**PLAN REVIEW SHEET**

Petition #: RZP 2020-035

Address: 6800 IBM Drive

Request: R-4 to UR-2 (CD)

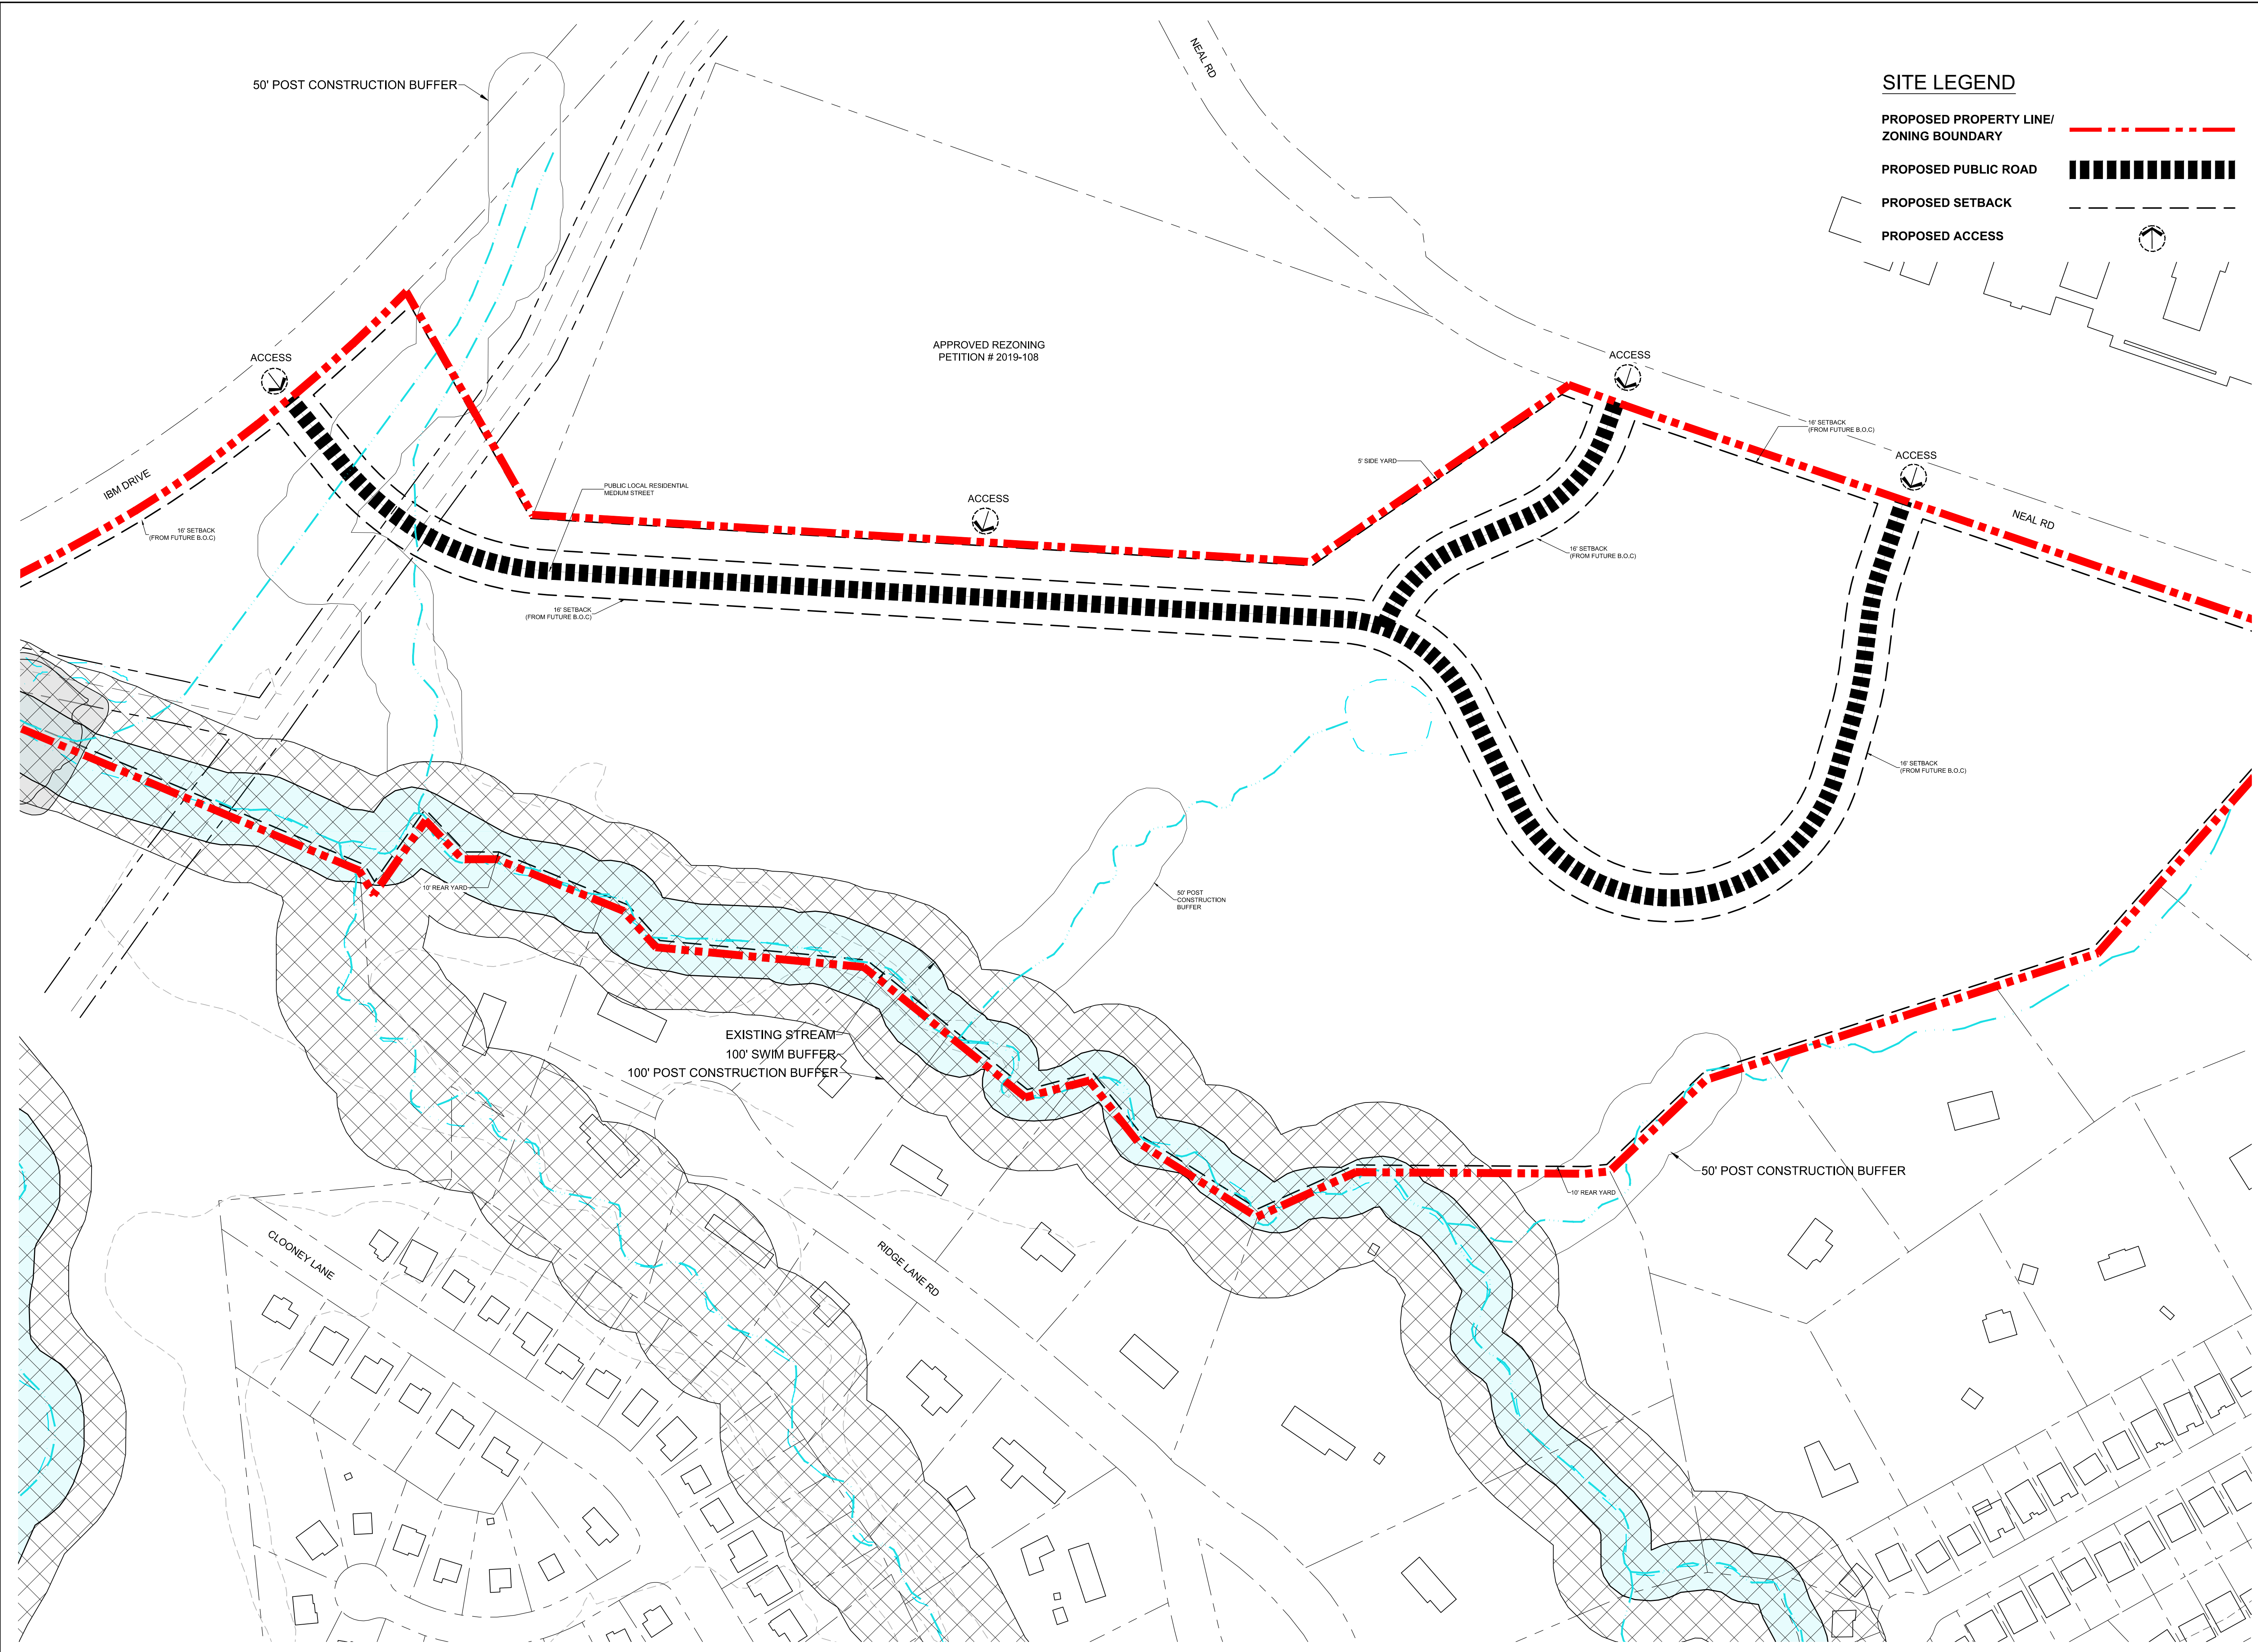
The site is located along CATS local bus route #54 on IBM Drive and Neal Road. CATS requests the petitioner to construct new ADA compliant bus waiting pads per Land Development Standard #60.03A at the existing stops on IBM Drive and a new pad along Neal Road. The final location of the pads will be coordinated with the developer through the permitting process.
